Subject: RE: 23452 Stakers Farm, Yapton - Y/52/22/DOC Designers Response

Further to the LLFA Response dated 9 December 2022 for information on the Discharge of Condition application Y/52/22/DOC, please see attached the designer's response with supporting documents.

Further to LLFA Response dated 20 September 2022 for information on the Discharge of Condition application Y/52/22/DOC, we have attached updated drainage drawing 201A_Proposed Drainage Plan together with revised calculations and construction details based on the comments received.
We reply to the following responses below in green as follows:

MANHOLE WITH HYDROBRAKE
(Scale 1:25)

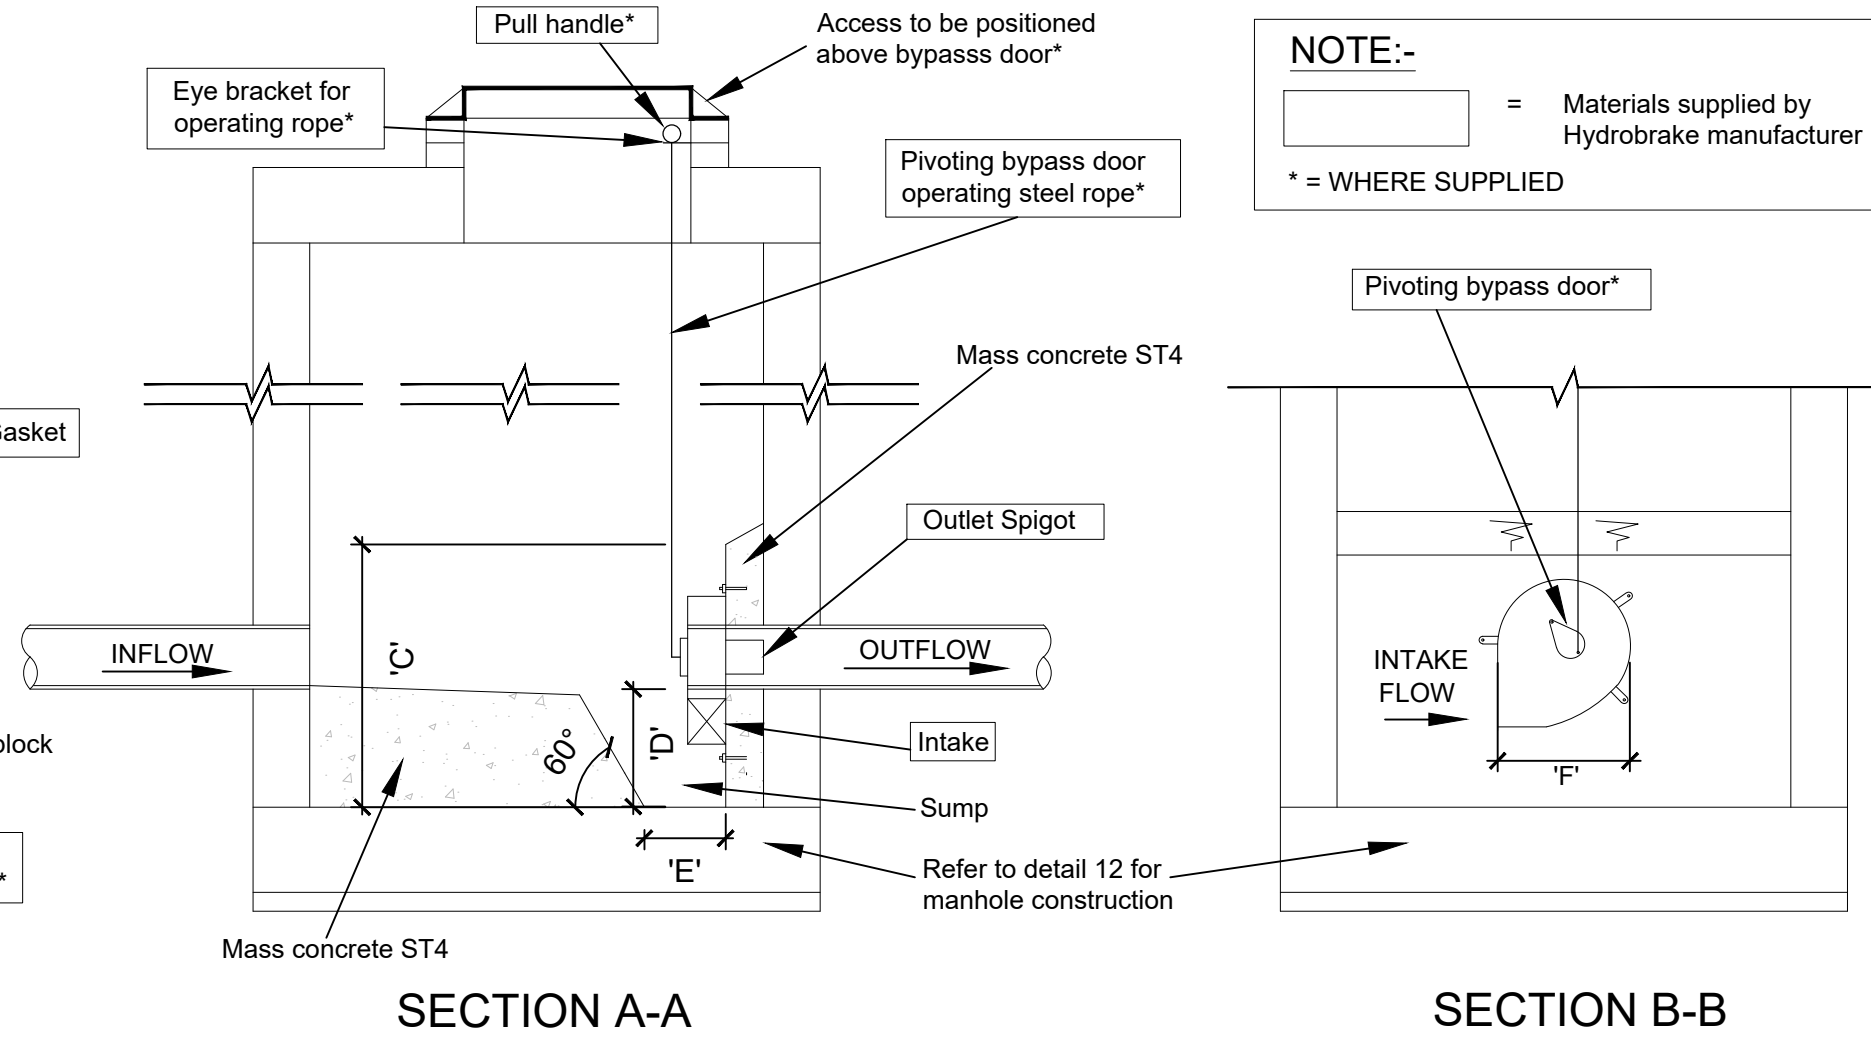
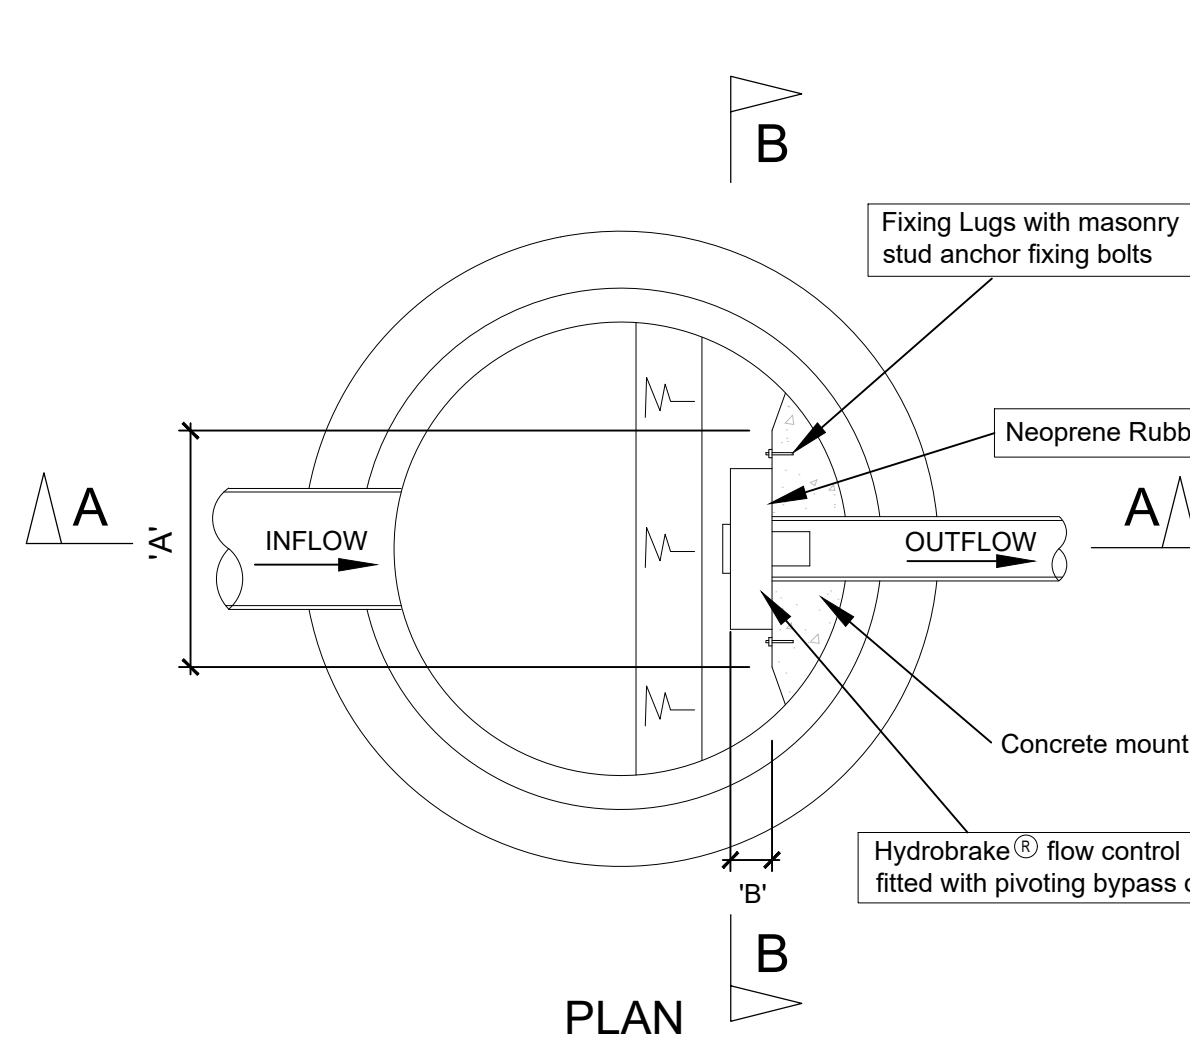
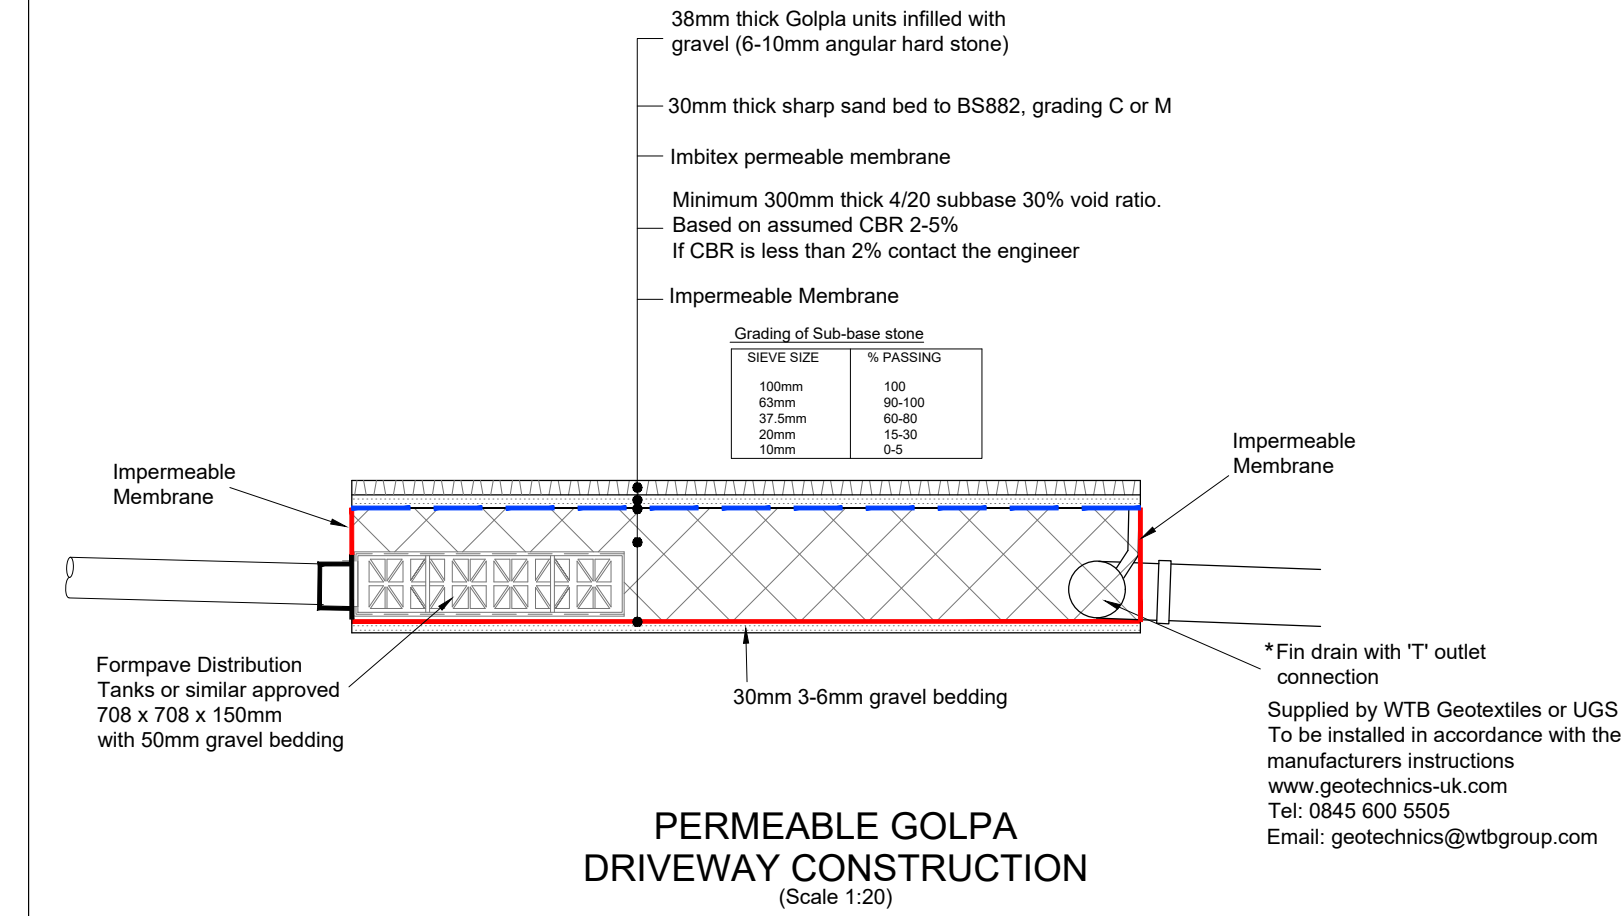
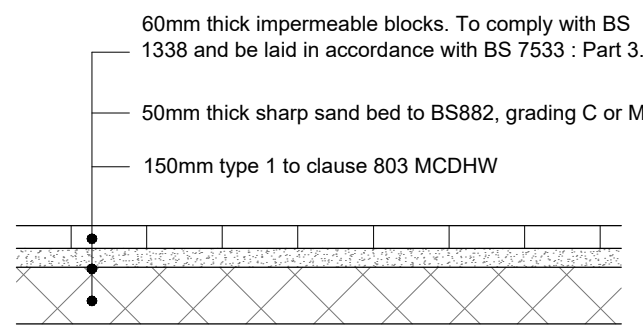
- The Hydro-Brake manhole is deeper than 1m, building regulations recommends manholes of this depth to have rungs or a ladder, which is not shown on the cross-section drawing. Justification for why this has not been shown should be provided, or the drawings updated accordingly. Construction details have been updated, hydrobrakes are proposed at less than 1m in depth, please see drawings S01B__Proposed Construction Details and 201A__Proposed Drainage Plan

BLOCK PAVING CONSTRUCTION
(Scale 1:20)

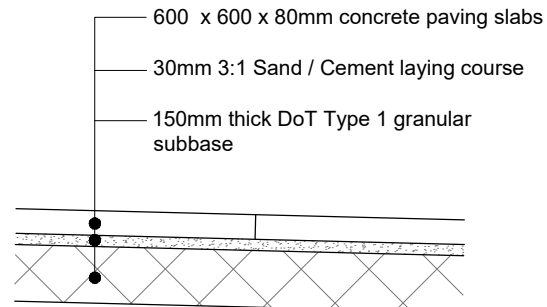
1. Additional information is required on the design drawings.
 - The invert level for the diffusion boxes has been provided, however, we request that the invert levels of the paving sub-base / bed levels are also provided in these locations, as the section drawing shows these to be

different. This is also being requested to enable us to check that the diffusion boxes are located above the critical 1:10 (+40% climate change) water level within the sub-base. Without these values insufficient information is available to confirm that the peak water level within the paving sub-base will be contained within the sub-base. The paving subbase formation level is 5.970m for the northern area and 5.400m for the southern area as shown on the drainage drawing 201A, copy attached. The design is not based on infiltration to ground and there is no requirement within Arun District Council Guidance or National Planning Practice Guidance for distribution tanks to be located above the 1 in 10 year storm event for storage systems.
